Your Ref: OWPC19353
Our Ref: R/134/18/PL 01-06-2018
Please ask for:
Mrs A Gardner

1 No. end of terrace two storey dwelling
8 Duncton Road Rustington

Thank you for your internet representation made on 19th July 2018 which has been recorded as '**an objection**' with the comments as follows:

Drawing P01      May 2018      Scale 1:100 @ A3  
Planning Drawing - Site Plan & Floor Plans

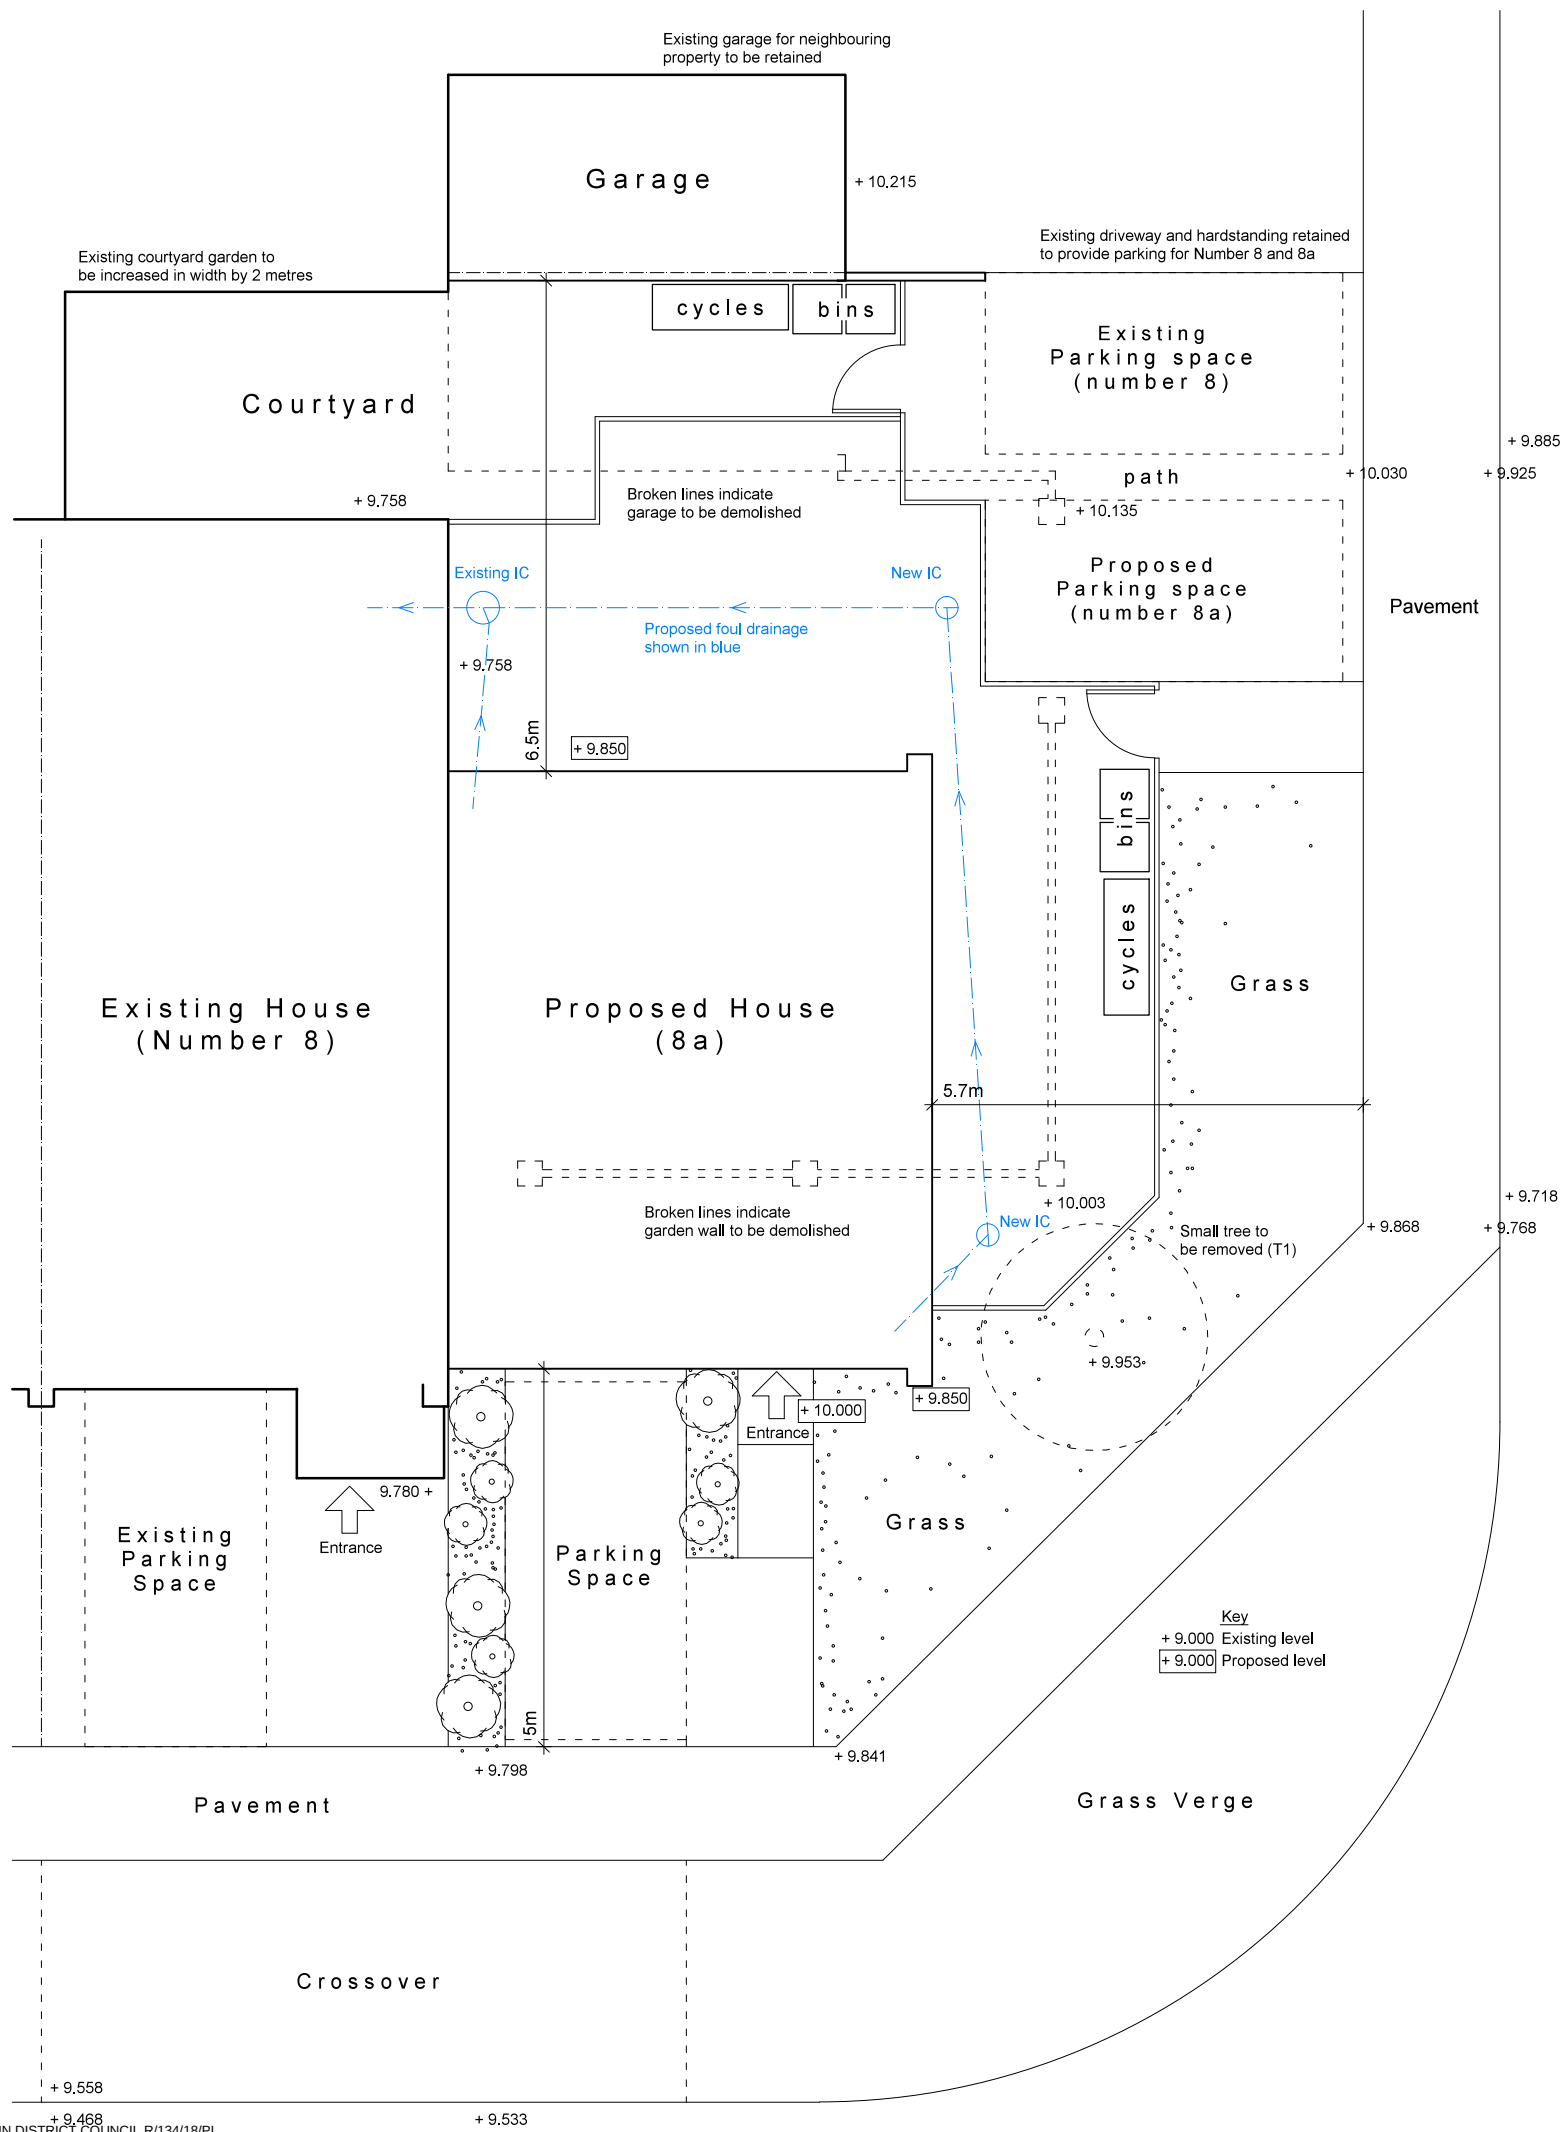
2) The proposed parking on the application is irrelevant as there is currently NO dropped curb at No.8 and insufficient space to park a car in front of the property as indicated in the drawings. The current occupant has driven his vehicles up over the curbs and grass, ruining the verges with no regard for his surroundings.
